WEST SUSSEX COUNTY COUNCIL CONSULTATION

TO:	Arun District Council FAO: Maria Tomalova
FROM:	WSCC - Highways Authority
DATE:	16 August 2019
LOCATION:	Rookery Farm Barn Hoe Lane Flansham Lane Bognor Regis PO22 6EP
SUBJECT:	Y/54/19/PD Prior approval for a proposed change of use of agricultural building to dwelling house (C3) and associated operational development under Schedule 2, Part 3, Class Q. Further details received.
DATE OF SITE VISIT:	n/a
RECOMMENDATION:	Advice
S106 CONTRIBUTION TOTAL:	n/a

Drawing Title: Proposed Ground Floor Plan

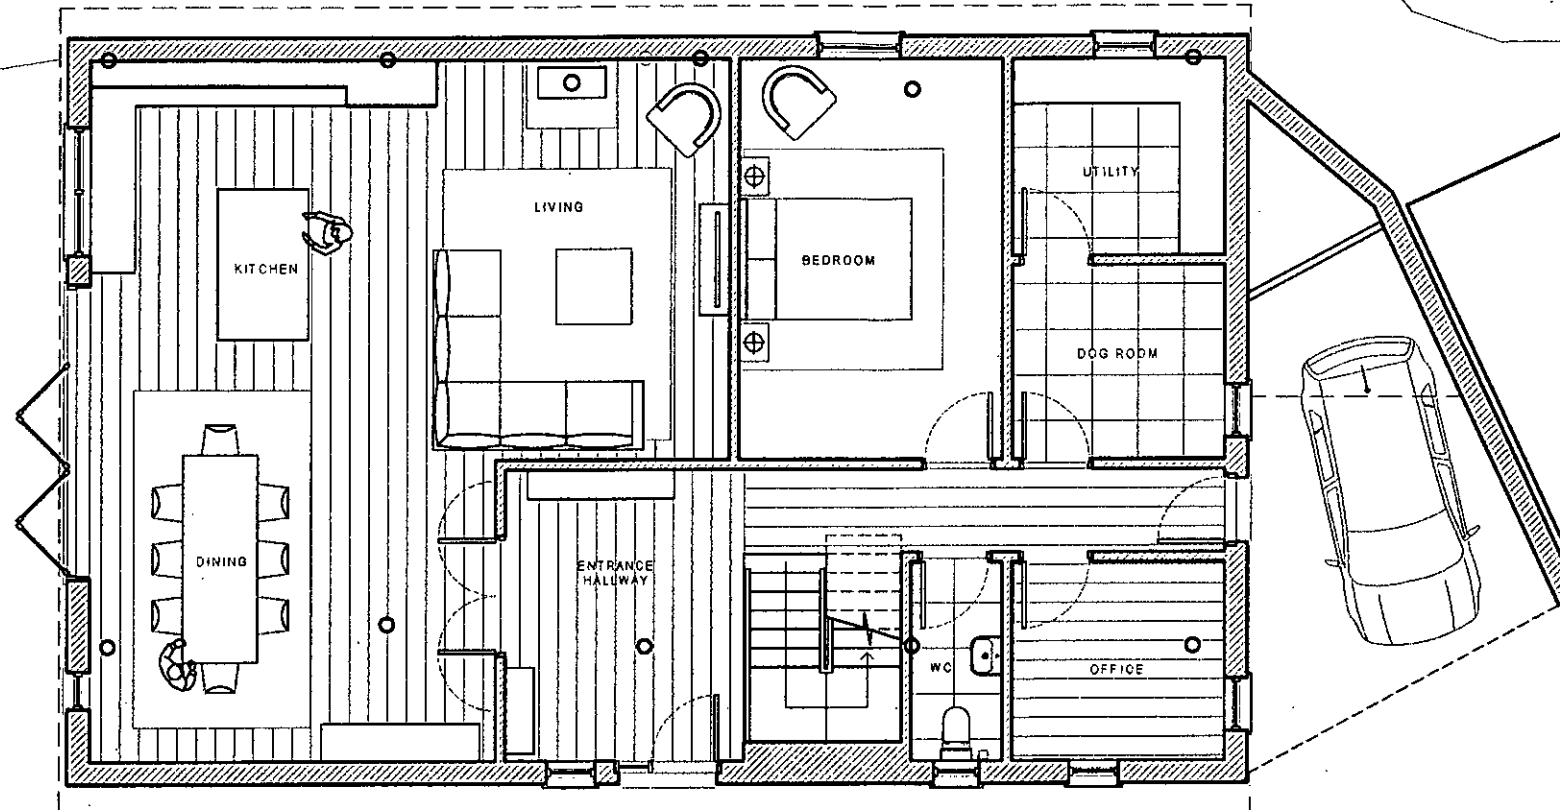
Under WSCC Parking Guidance (adopted August 2019), the LHA would anticipate that 2 parking spaces would be sufficient for a dwelling of this size and location. The applicant has demonstrated this.

The applicant has demonstrated cycle parking with in line with the WSCC Sustainability Policy. This will be located in a shed located adjoining the property.

No part of the development shall be first occupied until the car parking has been constructed in accordance with the approved site plan and details submitted to the Local Planning Authority. These spaces shall thereafter be retained at all times for their designated purpose.

No part of the development shall be first occupied until covered and secure cycle parking spaces have been provided in accordance with plans and details submitted to the Local Planning Authority.
